From: Maria Tomalova
Sent: 13 August 2019 13:29
To: Planning.Responses
Subject: FW: BR/154/19/PL, 8 Mead Court
Attachments: Site Plan.pdf

Subject: BR/154/19/PL, 8 Mead Court

SITE PLAN - 1/500

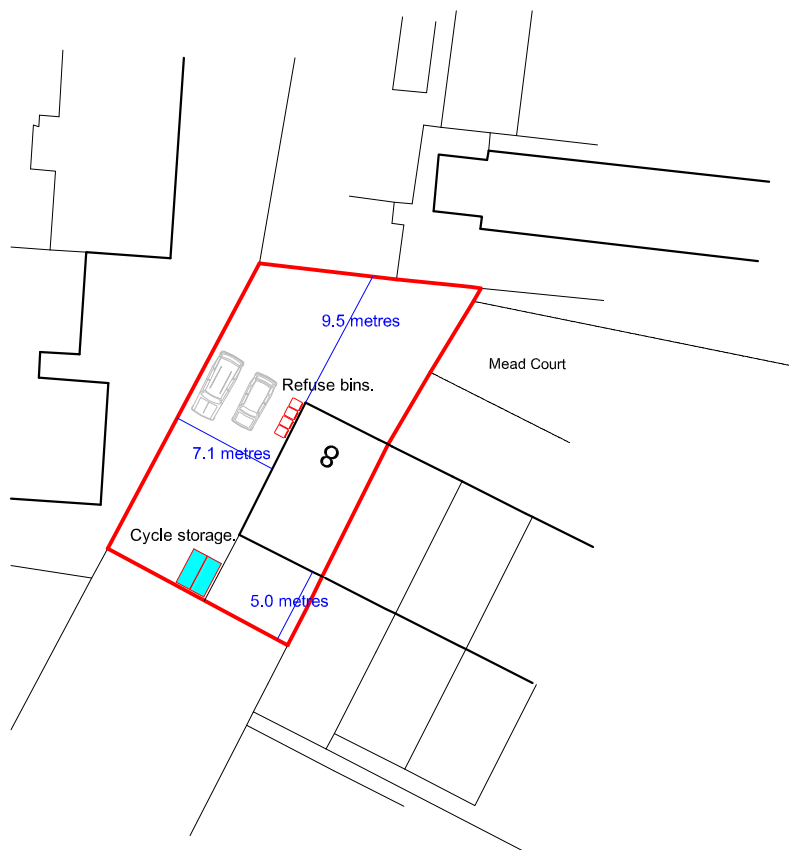
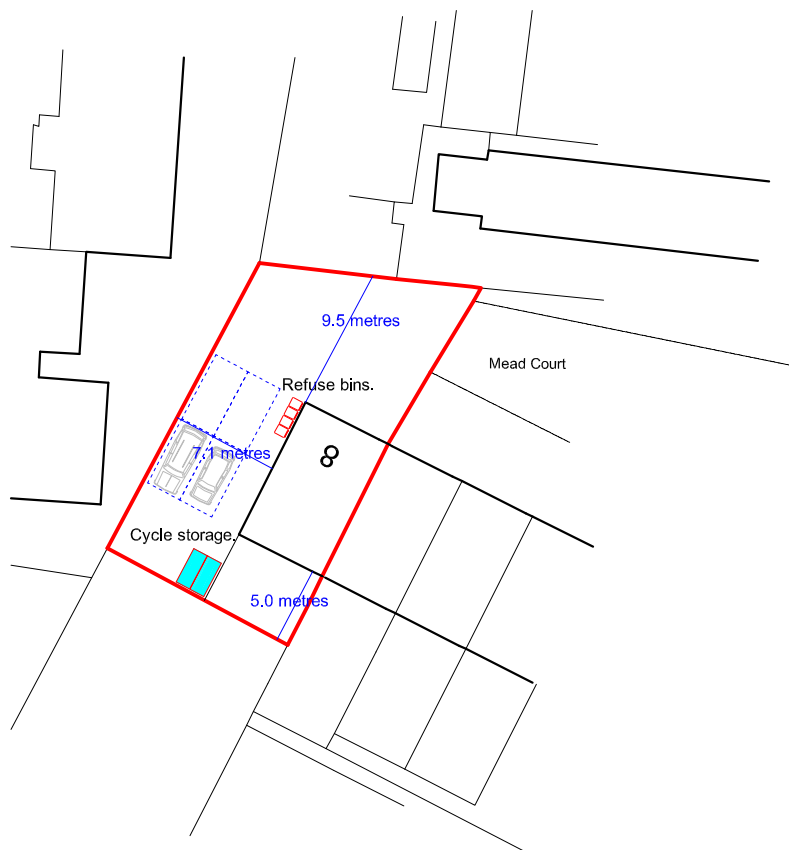
One of the grounds was a lack of parking spaces provided.
I have been on the site and the site is big enough to accommodate 4 cars,
What is a requirement for 8- bed HMO.

It would be helpful if you can demonstrate the provision of 4 parking spaces.

The site as you will know is more than capable of taking twice the amount, however, I attach a copy of a revised site plan indicating 4 x spaces as requested -- I trust that this is ok?
